Application number: 2025/92628	
What is the application for?:	Erection of dwelling and associated works (within a Conservation Area)
Address of the site or building:	adj, 42, Long Croft Street, Golcar, Huddersfield, HD7 4EA
Postcode:	HD7 4EA

Ref: Planning Application 2025/62/92628/W; adj, 42, Long Croft Street, Golcar, Huddersfield, HD7 4EA

HOUSE TYPE 01 GA PLANS & ELEVATIONS 1:100 @ A1

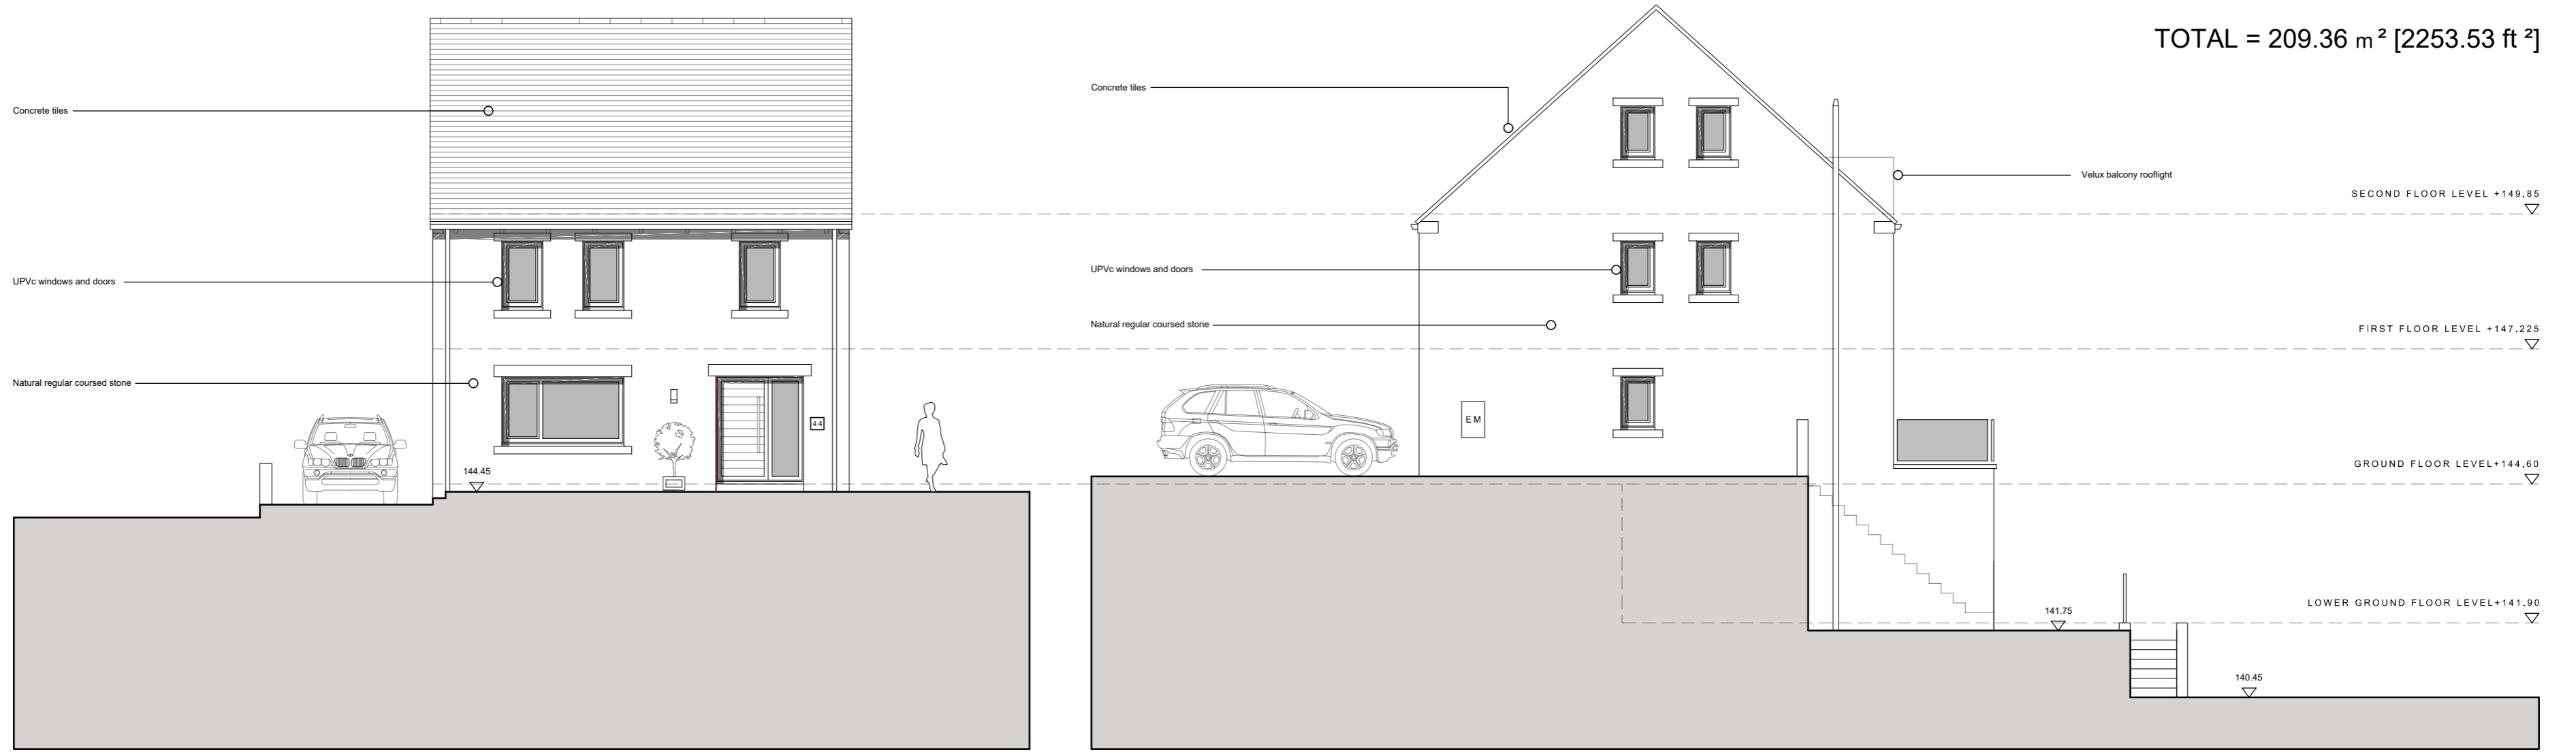
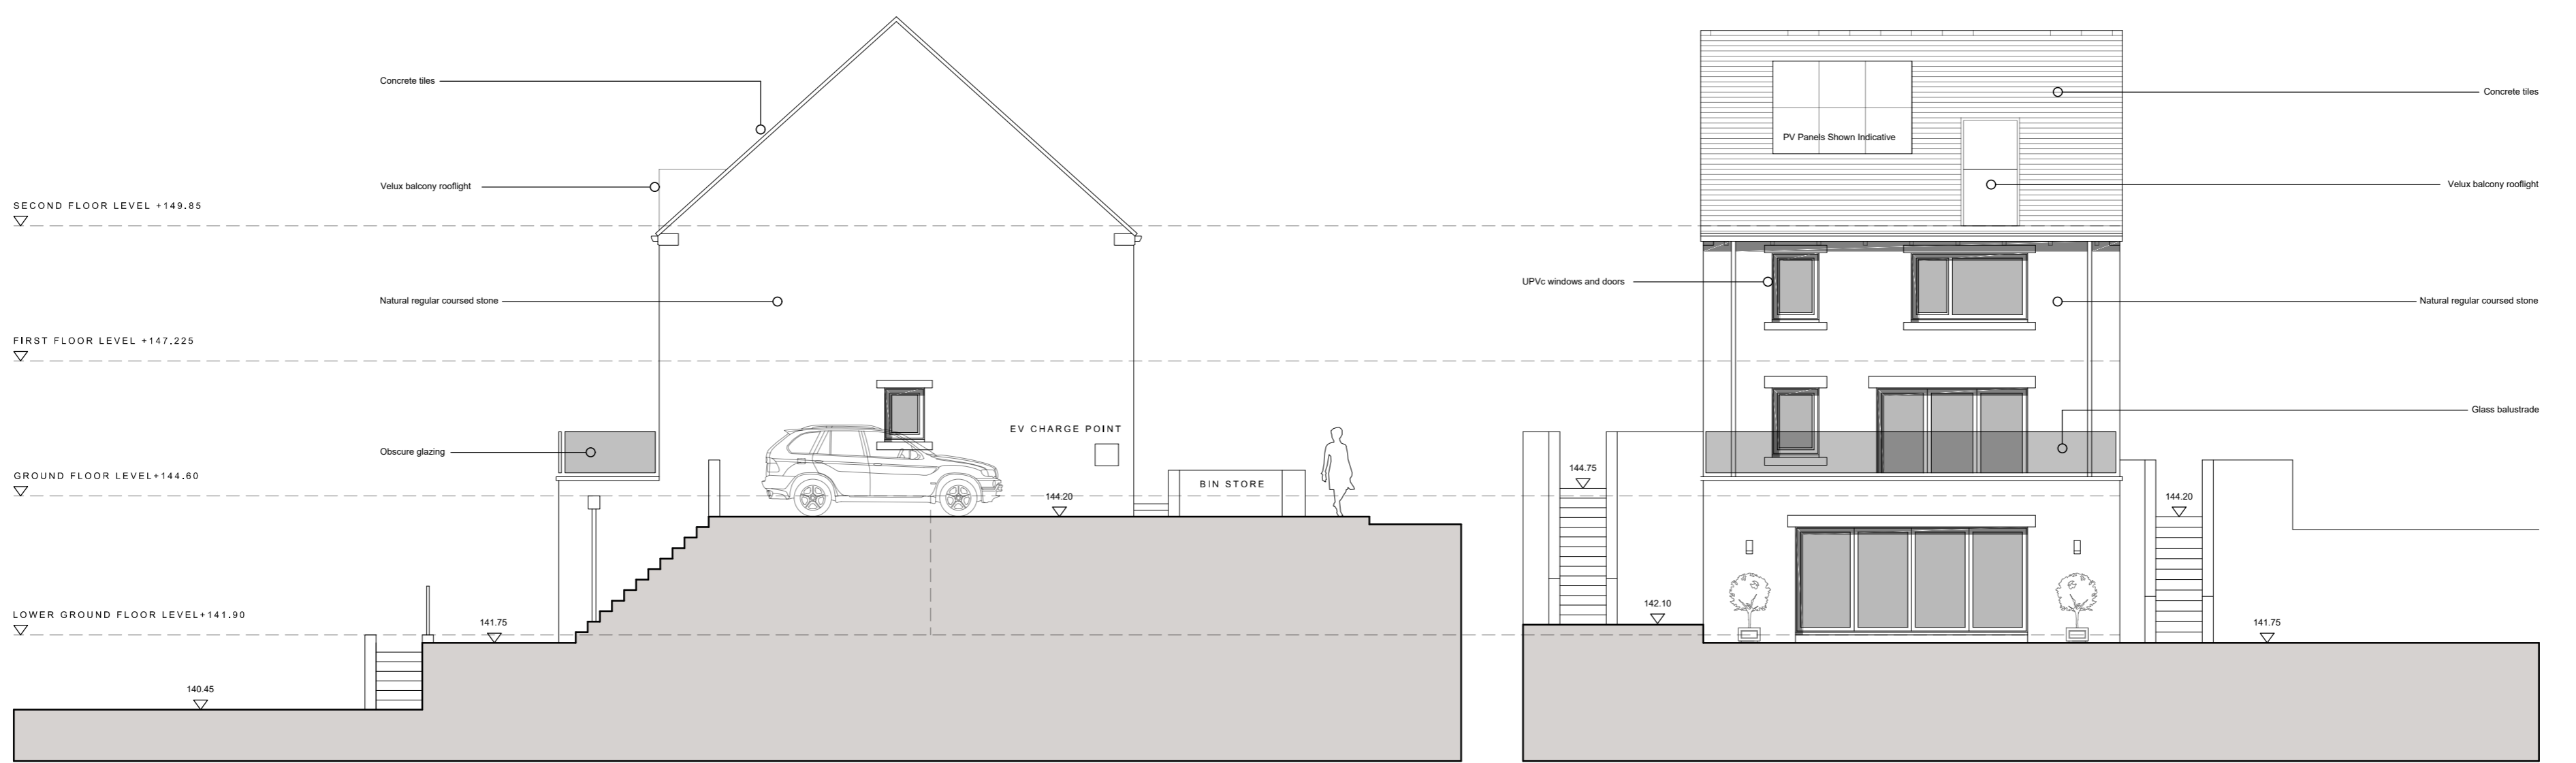
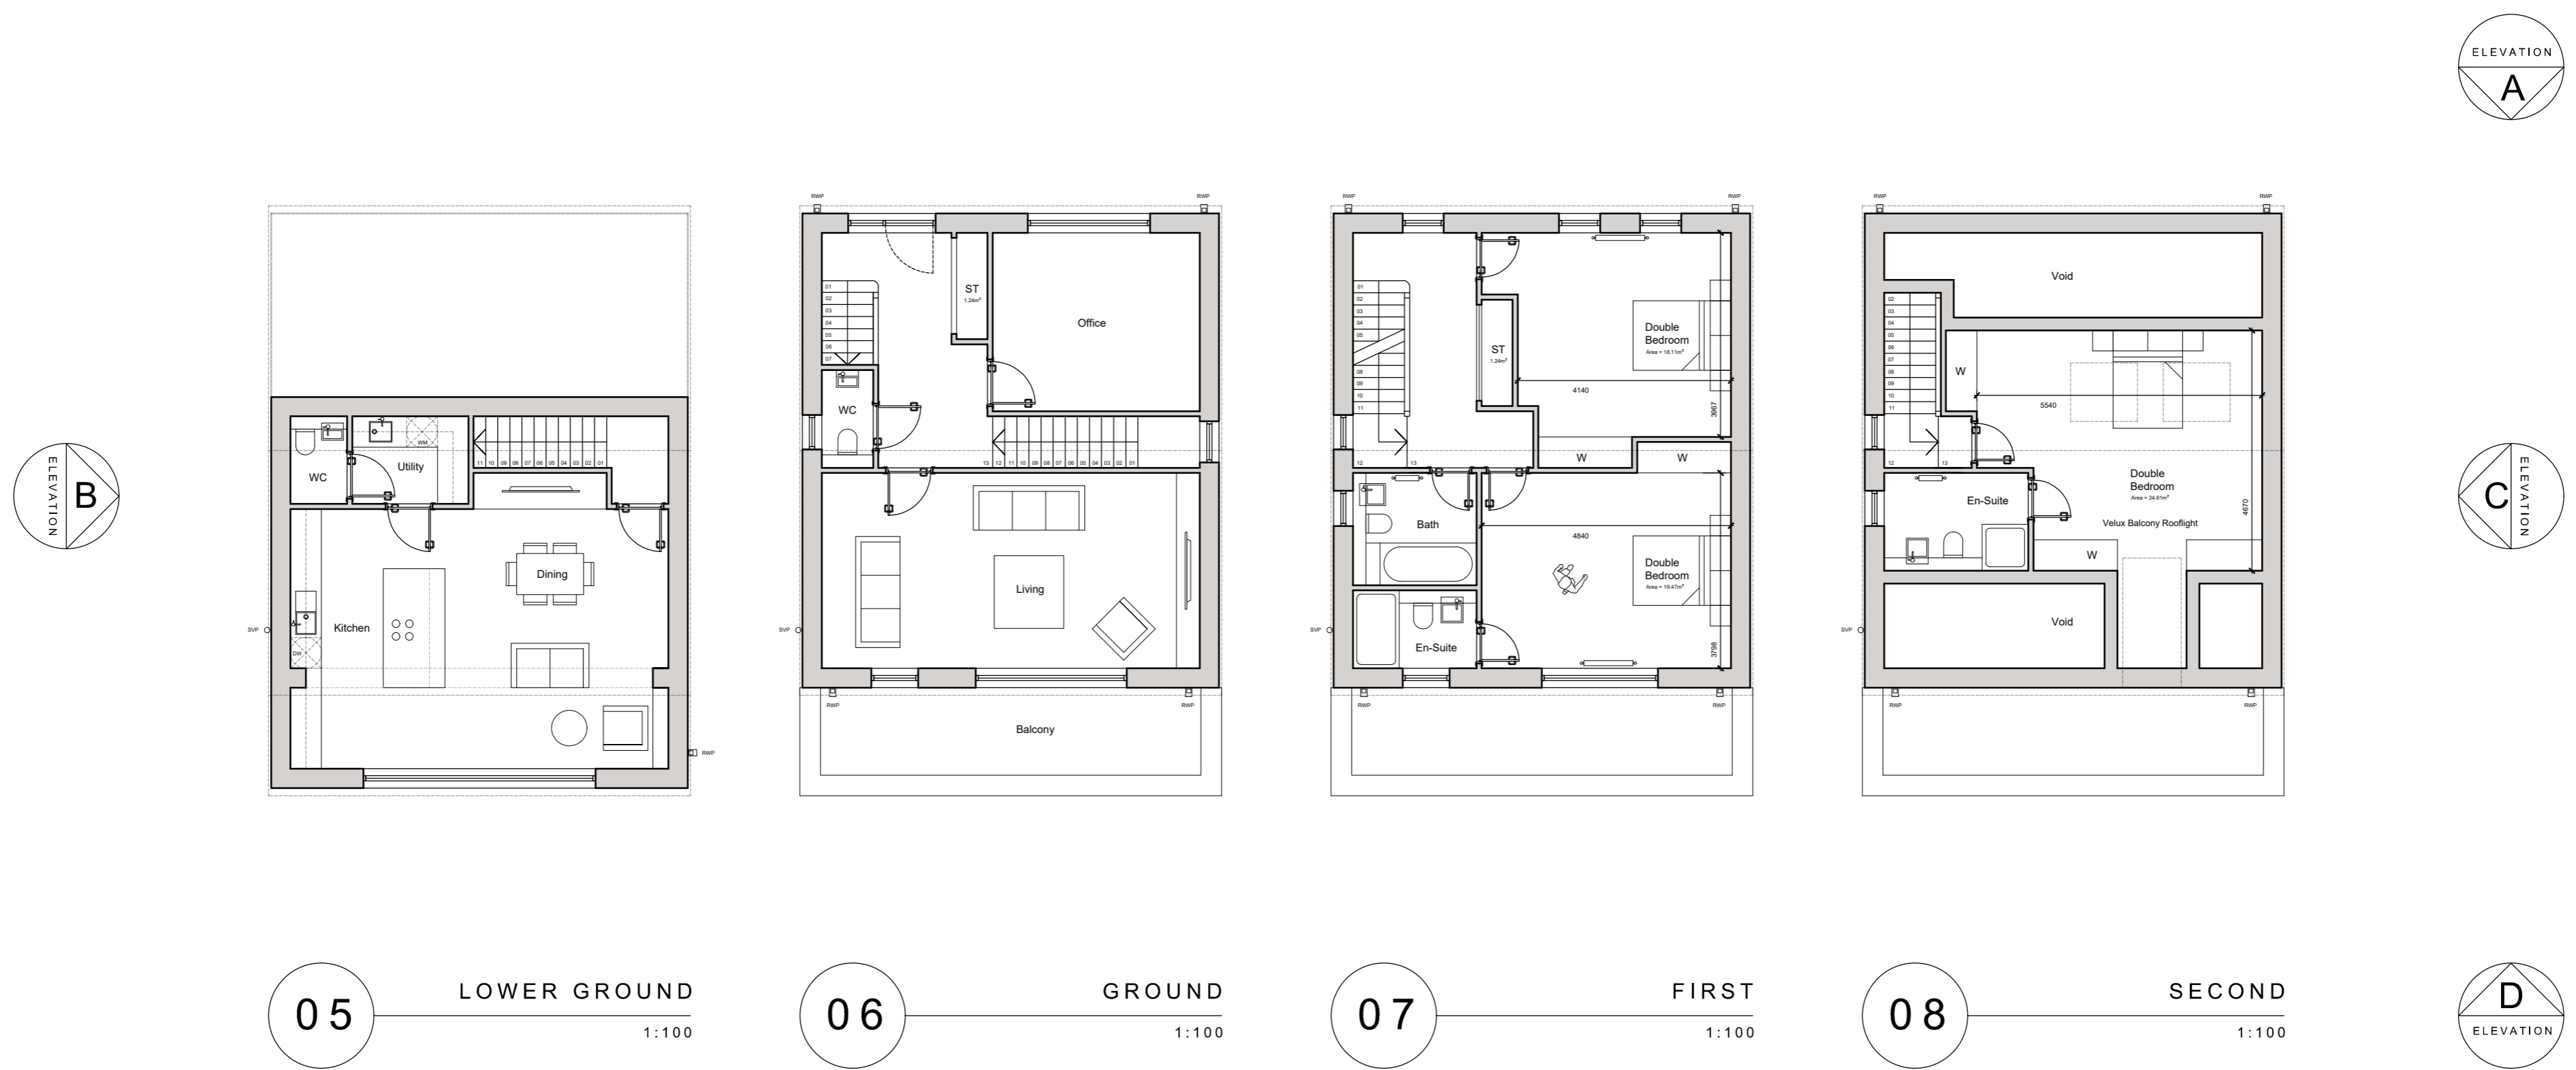
Design - The scale and siting of the rear aspect of the property, notably the large balcony and extended part of the lower ground floor would not respect or enhance the character or appearance of the Golcar Conservation Area. The scale, design, and siting is not in keeping with, or in line with, the adjacent 3 bedroom properties. It would impact the visual amenity of the area which can be seen not just from the nearby properties but from the road below and widely from across the valley.

Overlooking and Loss of privacy - The large balcony and lower ground floor extend well beyond the line of existing properties and would therefore closely overlook the private gardens of the adjoining properties of 42 and 46 Longcroft Street, but could also overlook further properties due to the small size of the adjacent gardens. This would result in a significant impact on the residential amenity of neighbours.
